Cellars Clough, Marsden

Road Safety Audit
Stage 1
August 2018

Project No: 1048

Proposed Access

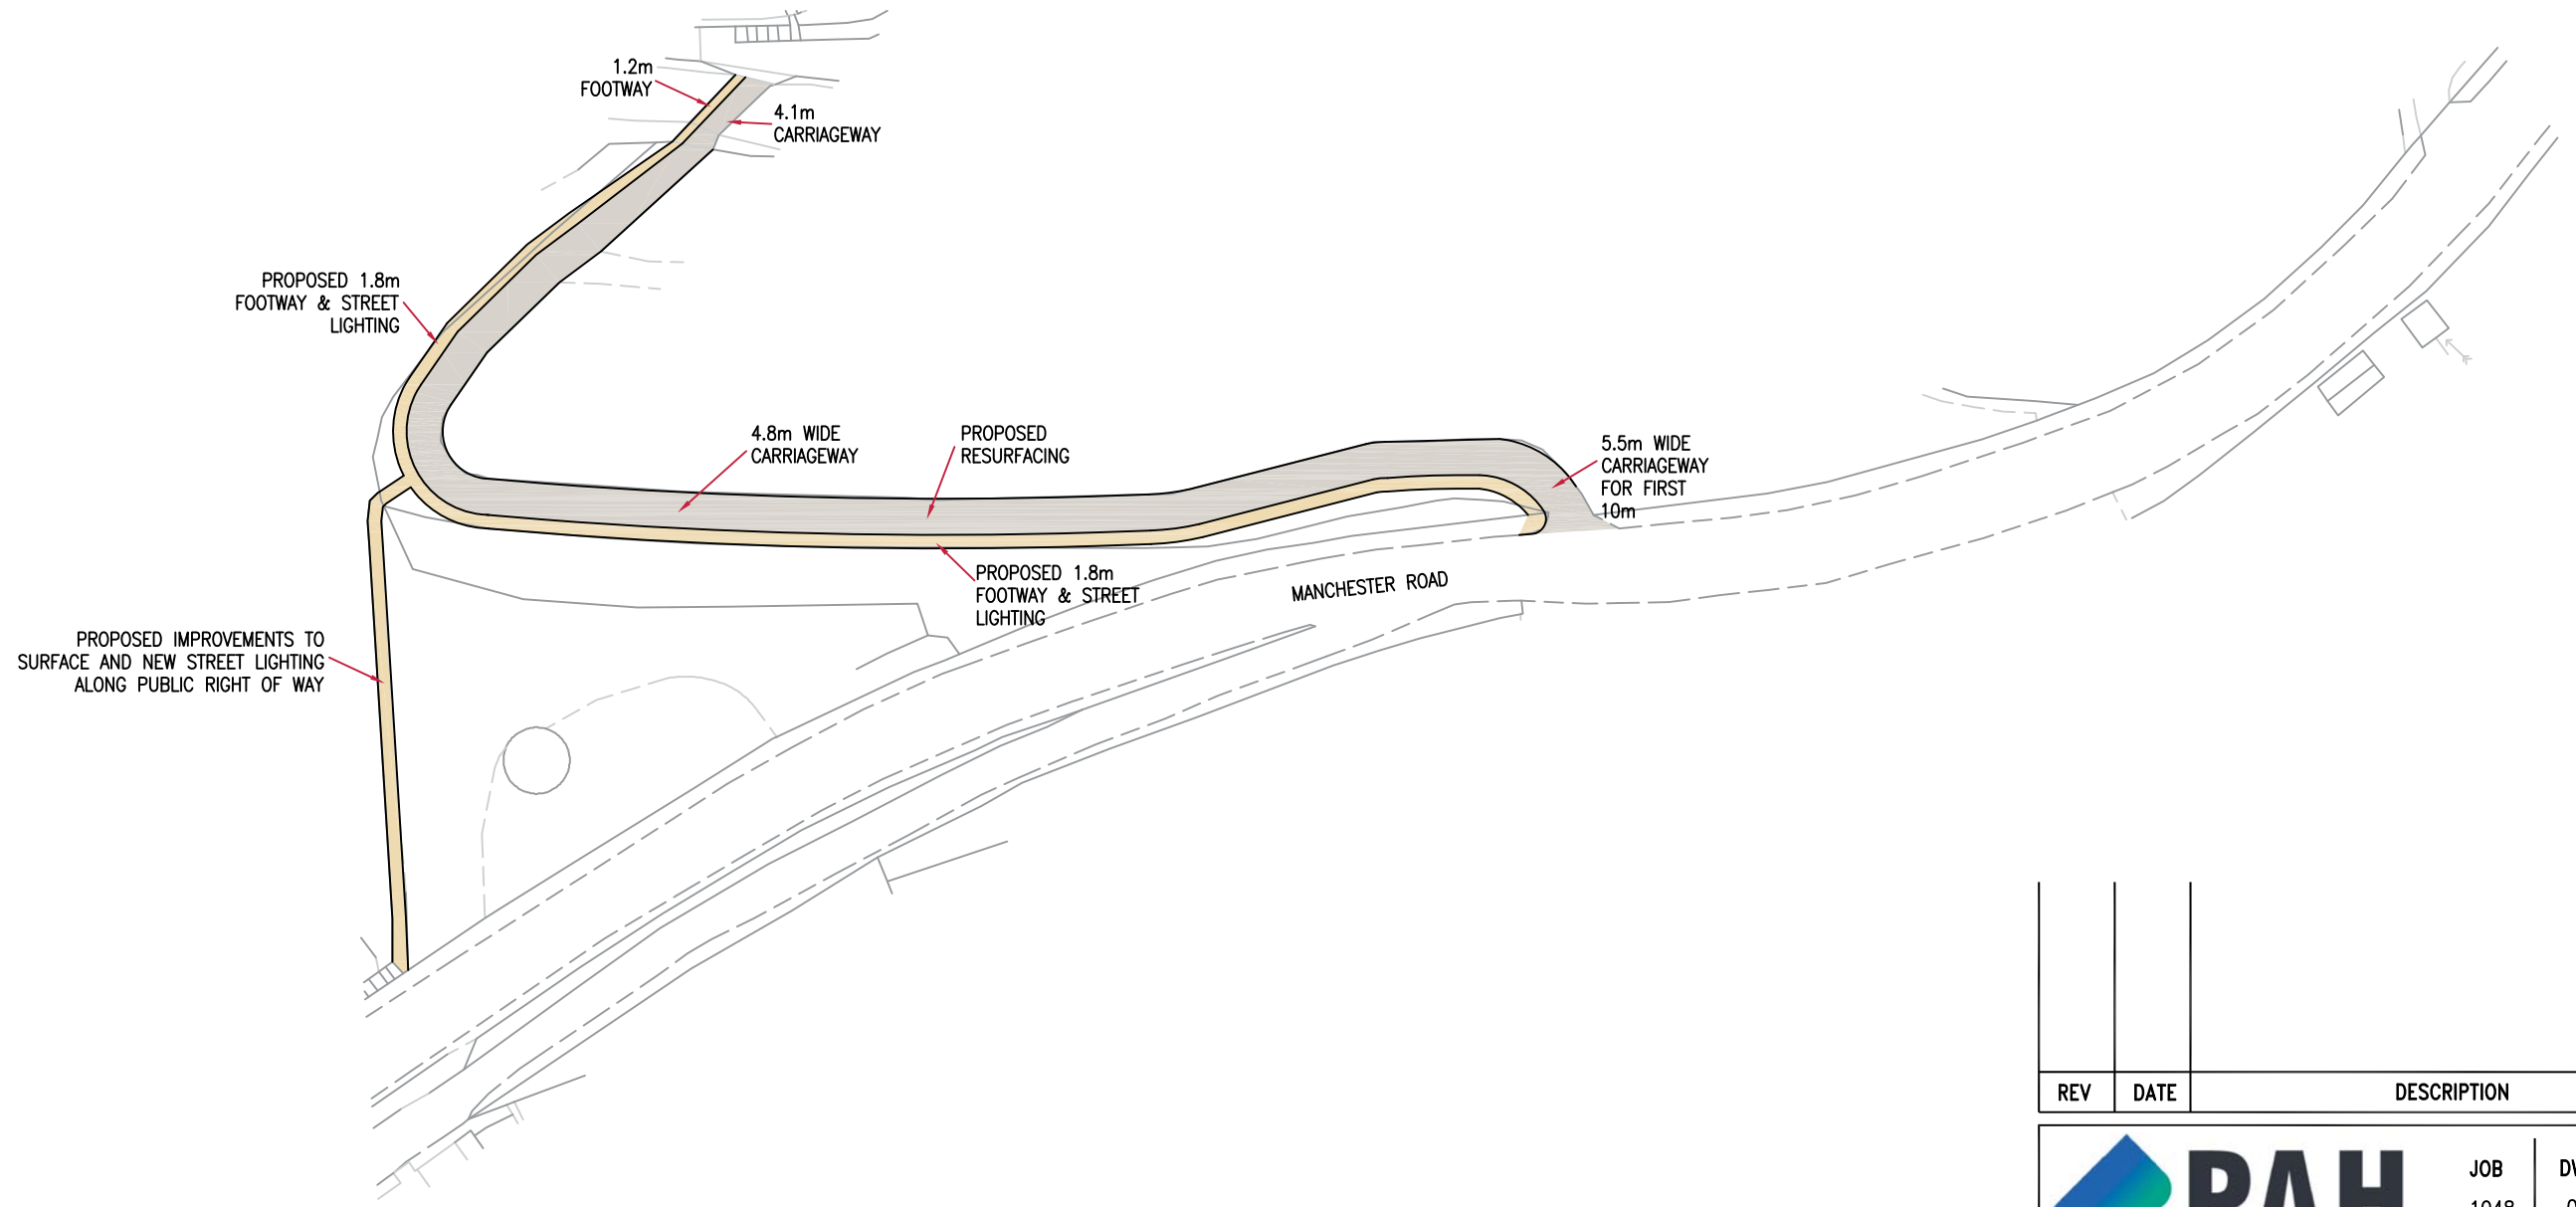
Detail: Two new refuges are proposed on the A62 Manchester Road on each approach to the access road. There is limited forward visibility especially travelling west bound and no details have been provided about the type of refuge and whether they are intended for pedestrians. There are no illuminated bollards shown and given that the road is bounded by trees and vegetation, which is very dense causing dark areas on the carriageway, there is a risk that vehicles may collide with them.

Detail: There are several gullies along the north side of the A62 Manchester Road where the carriageway is being widened (See Images below). There are no details of any proposed drainage or the relocation of the gullies. If the carriageway is not drained adequately there is a risk of flooding / standing water which may lead to vehicles losing control. This problem is exacerbated during the winter months due to low temperatures and freezing conditions.

Detail: There are several manholes in the footway along Manchester Road in the area where the carriageway is being widened. There are no details of the relocation of the manholes and some appear to be along the proposed kerb line. If these manholes cannot be relocated or adjusted they will create a hazard for pedestrians.

Detail: A new vehicle restraint barrier and pedestrian guard-rail is proposed along the new footway on the access road but the embankment between chainage 0 and 30 is unprotected. This could lead to an errant vehicle negotiating the bend leaving the carriageway with an increased risk of severity.

Detail: Although the carriageway is being widened and a 90-metre visibility splay is shown, there is a stone wall on either side of the access and it is unclear if this is being removed to improve visibility. There is also heavy vegetation to the east of the access road, outside the highway boundary including large mature trees which obscure sightlines around the bend on Manchester Road, when pulling out of the junction; especially for larger vehicles. It is also not clear whether this vegetation is being removed or cut back.

Detail: There are some posts in the footway to the west of the access road which are assumed to have had a chevron board on at some time (See Image below). If the footway is reduced at this point to 1.9 metres as shown on Drawing No.1048:101 there is a risk that the footway will not be wide enough for pedestrians with pushchairs or wheelchair users if the chevron board is reinstated. This may result in pedestrians stepping into the road. It may also obscure the sightlines when exiting the junction. There are chevron boards further west along the road which may also need relocating if the footway cannot accommodate them.

Detail: The access road has a severe bend near to the junction with the A62 Manchester Road with a steep gradient at the start. The forward visibility when turning in from the west is blind and due to the layout and topography there is a risk of collisions between vehicles at this point, especially larger vehicles which require a bigger turning circle. It is also unclear whether the stone wall is to remain at the back of the footway on the A62 which also restricts visibility.

Detail: The access road to the new development also serves a Healing Centre and at the junction with the access to the Healing Centre there is limited visibility due to overgrown vegetation and the layout of the road. There are no details shown of any priority at this intersection and there is a risk that vehicles will be in conflict if increased traffic is using the road. Drawing No.1048:101 also appears to show that the pedestrian guard rail extends across this access.

Detail: A new footway is being provided along the access road from chainage 30 but there is no provision at the start of the road for pedestrians. This road is also signed as a public footpath. This location is considered the most vulnerable as it is a very tight, blind bend with restricted turning movements, especially for large vehicles. The vehicle tracks shown on the drawing suggest that a refuse vehicle will take most of the carriageway at this point to manoeuvre round the bend. If pedestrians step off the new footway into the carriageway and a vehicle is turning in they may be unaware of each other resulting in an increased risk of a collision.

Detail: The proposals do not show any provision of dropped crossings on the access road at its junction with the A62 Manchester Road or at the access to the Healing Centre. Failure to provide crossing points for pedestrians could lead to trips and falls or crossing at inappropriate locations resulting in collisions with vehicles.

Detail: The proposals show a new refuge island on the western approach to the junction with the access road, in the central hatching. It is proposed to be positioned opposite a public footpath which is signed and accessed from Manchester Road through a gap in the stone wall (see Image below). There are no dropped crossings shown on either side of the carriageway at this location and there is no footway on the southern side of Manchester Road so it is assumed that this refuge is not intended for pedestrians. The refuge may encourage pedestrians to cross at this location if it is not made clear that it is not intended for this purpose.

Detail: The proposals show some new hatching, a new right turn pocket and direction arrows. The existing lining is a double white line system through the series of bends that the scheme extends (See Image below). The double white lines prevent overtaking through this series of bends and restrict parking. If this is not included in the proposals, there is a risk of collisions from inappropriate overtaking with an increased risk of severity.

Accepted – indicated on drawings.

Accepted – access widened to accommodate a 11.85m long refuse vehicle.

Provision for pedestrians considered as part of the design. Slow moving vehicles through the junction, therefore, potential for collision considerably reduced.

Accepted – refuge islands shown.
